RE: Grading and Drainage Plan for Cordova Residence, Lot 27, Block 12, Tract 1, Unit 3, NAA, (B19/D11) Engineer's Stamp Dated 3/27/98.

***RE: Engineer's Certification for Cordova Residence, Lot 27, Block 12, Tract 1, Unit 3,
NAA, (B19/D11) Engineer's Certification Stamp Dated 11/17/98.***

CORDOVA RESIDENCE
GRADING & DRAINAGE PLAN

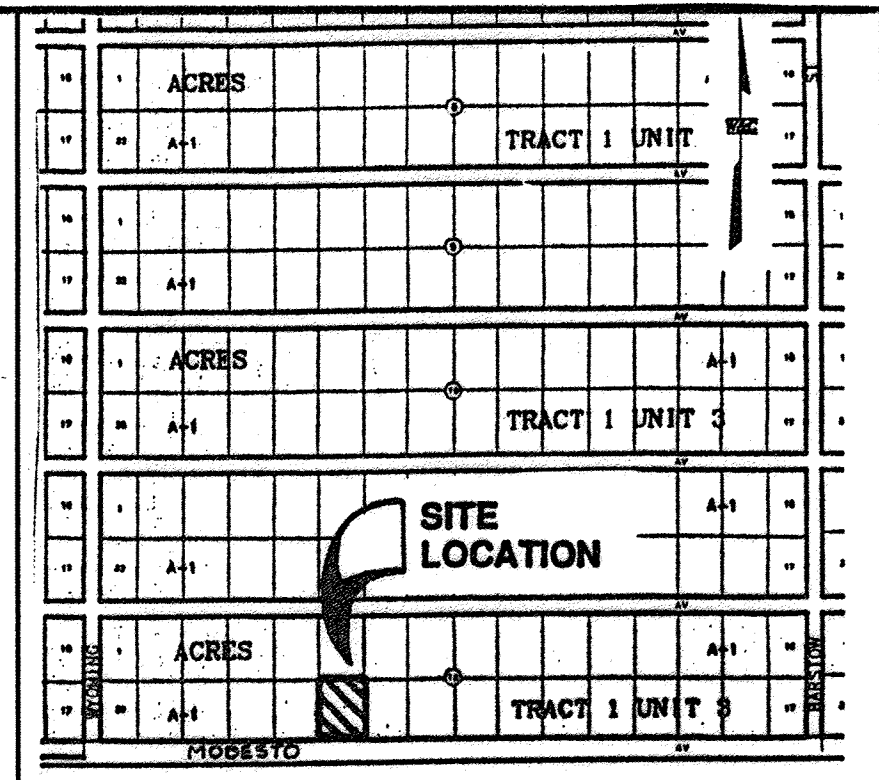
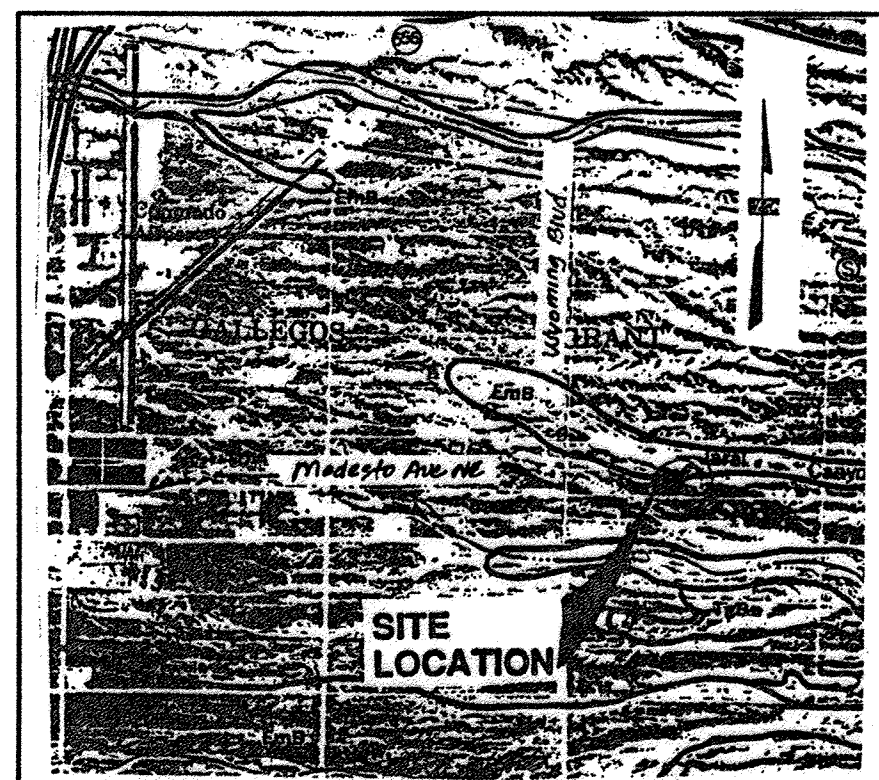
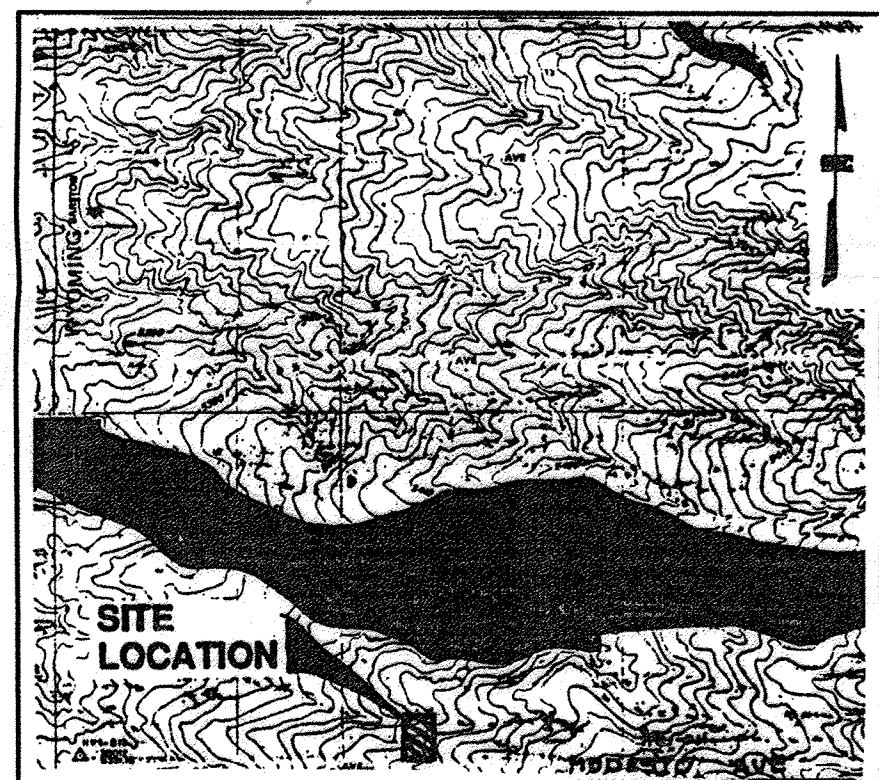
As you are aware, the Engineer's Certification, including the certification of the rip-rap, is required prior to Certificate of Occupancy release for this residence. On the Certification, please clean up the plan, identifying the basin area and runoff amount for Basins 101 and 102.
